RIVERSIDE SELF STORAGE CONTAINERS
 Portland, Maine

Document Title:
 Shipping Container
 Storage Foundation
 Drawings

Sheet Title:
 DETAILS /
 SECTIONS

PARTIAL FOUNDATION PLAN

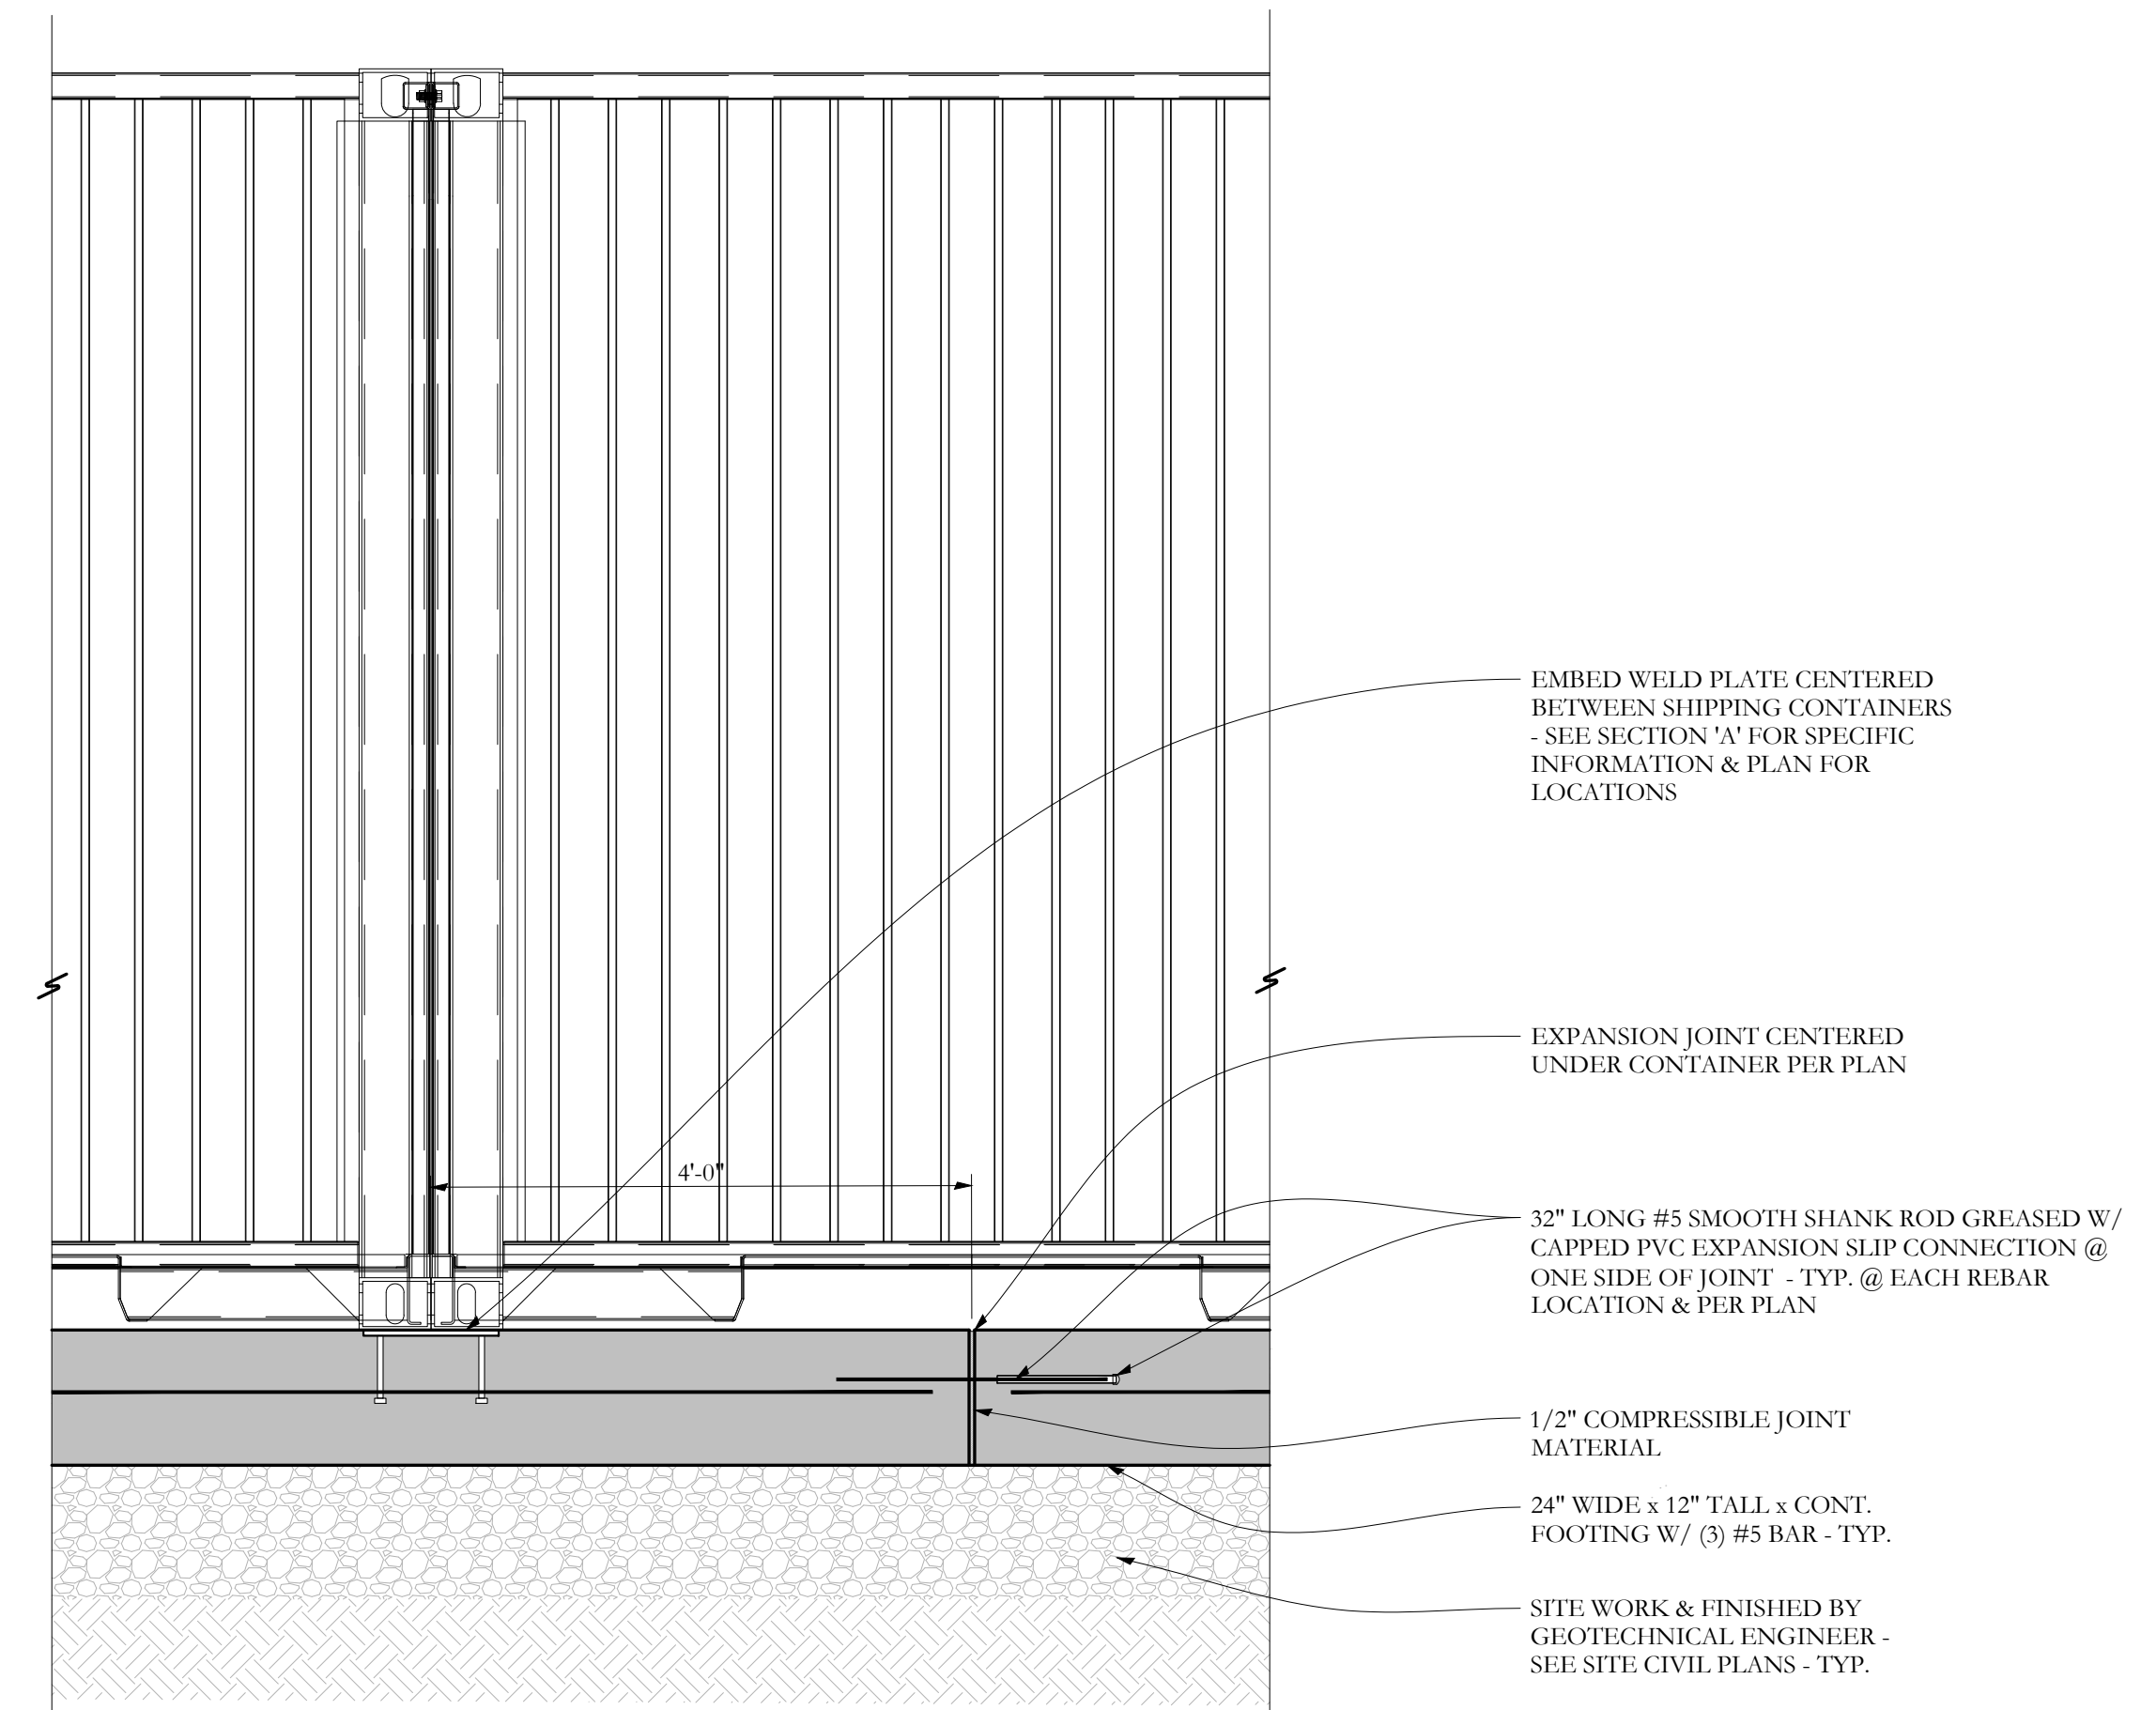
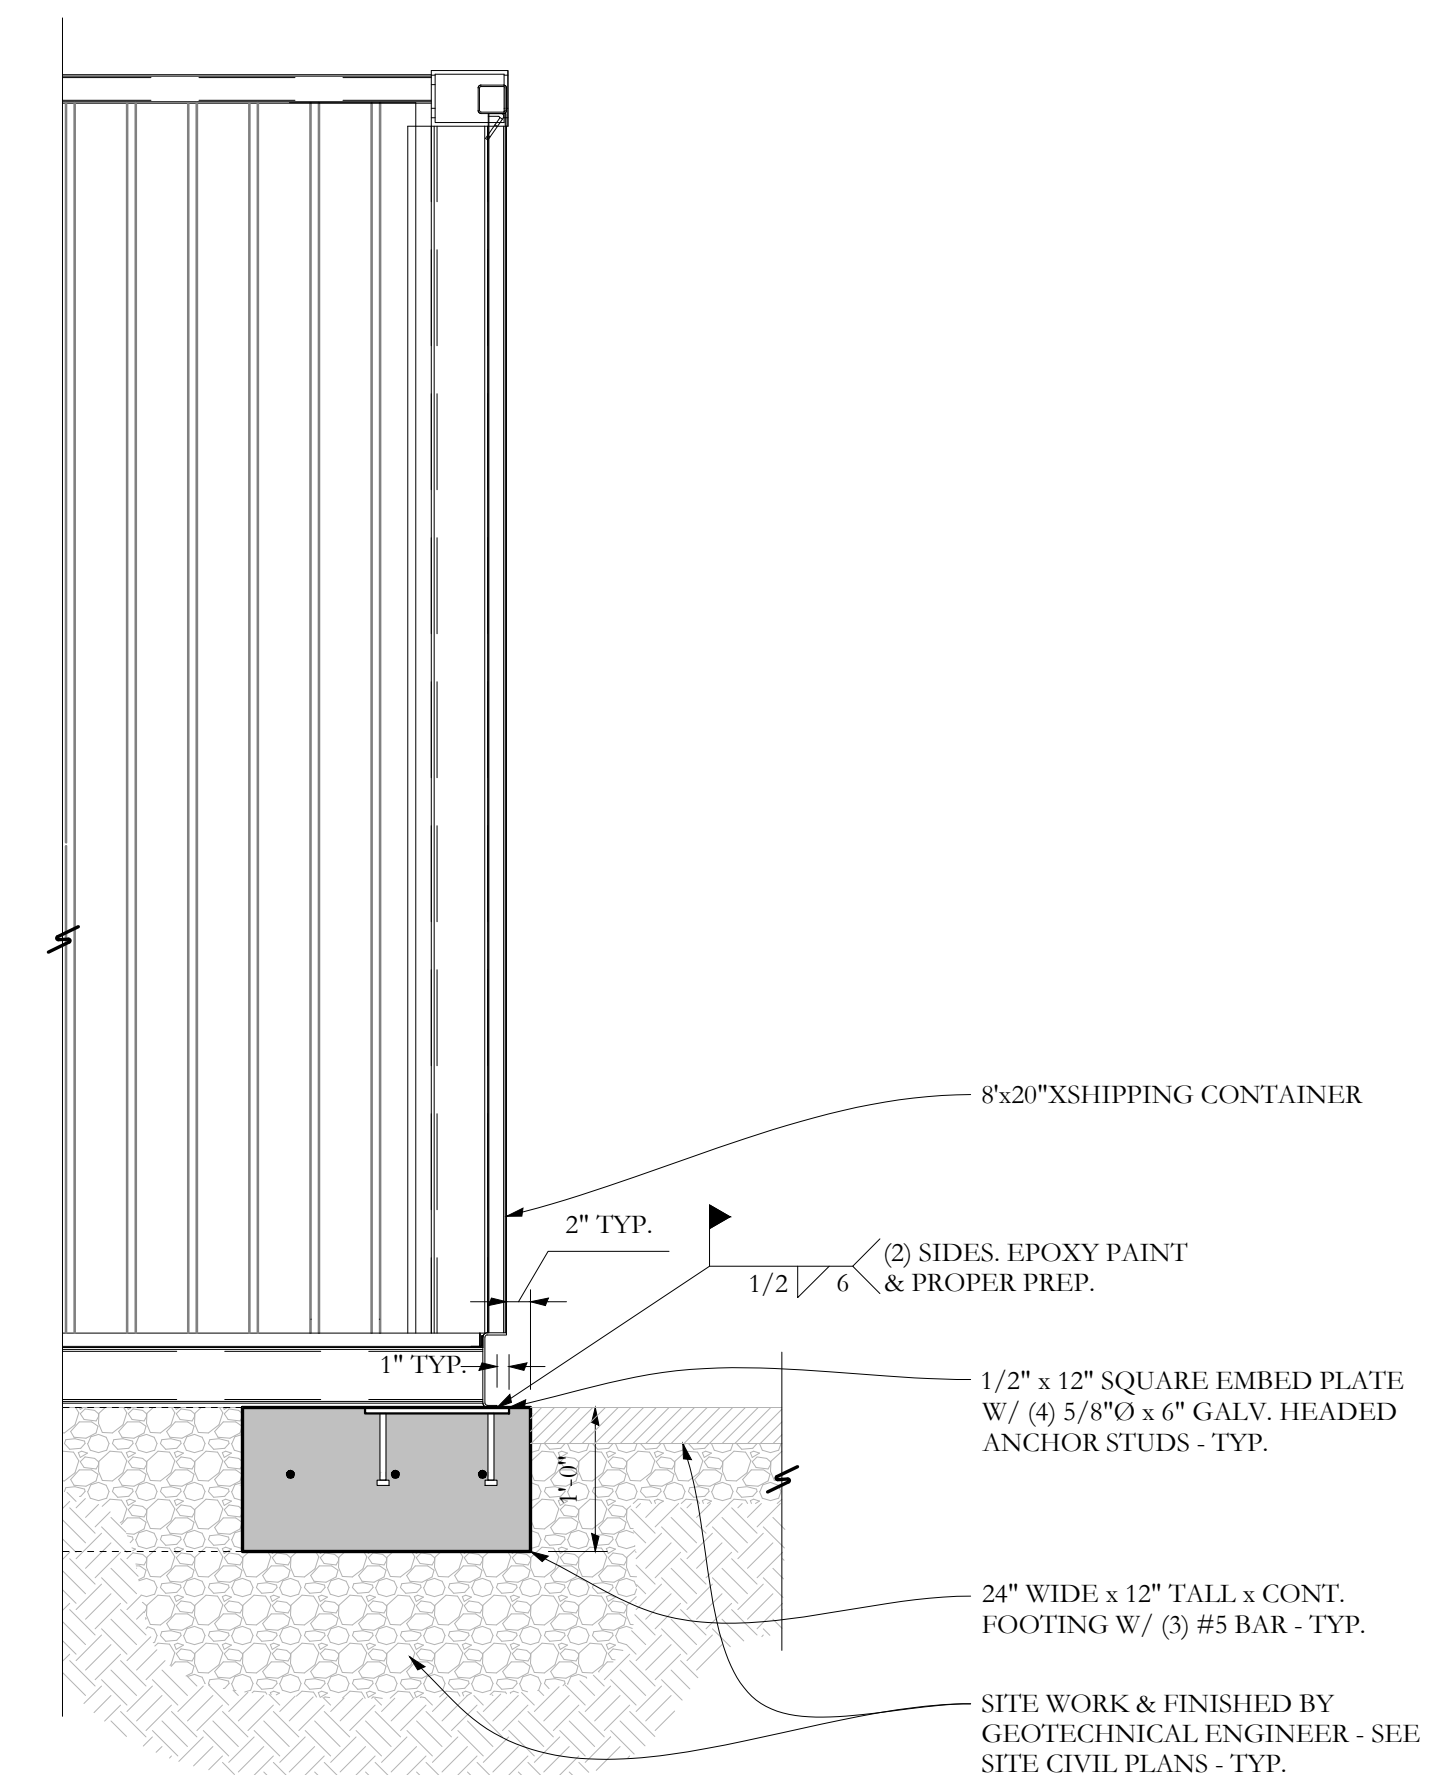
Please provide a code analysis for the frost protection of the foundation. How is this design meeting that criteria?

SI Response: Per IBC1805.2 structures in Occupancy Category 1 don't need to meet full frost protection and only need 1'-0" deep foundations. Minor storage per ASCE 7 is considered Occupancy Category 1

Are the proposed weld plate spacings and welds providing sufficient anchoring and attachment for each of the containers for the imposed wind loads? How are the units inbetween the plates anchored? Provide supporting data to confirm this.

SI Response: each unit is independently stable and doesn't need to be tied to the adjacent units for stability. The end of the rows are welded to prevent incidental movement.
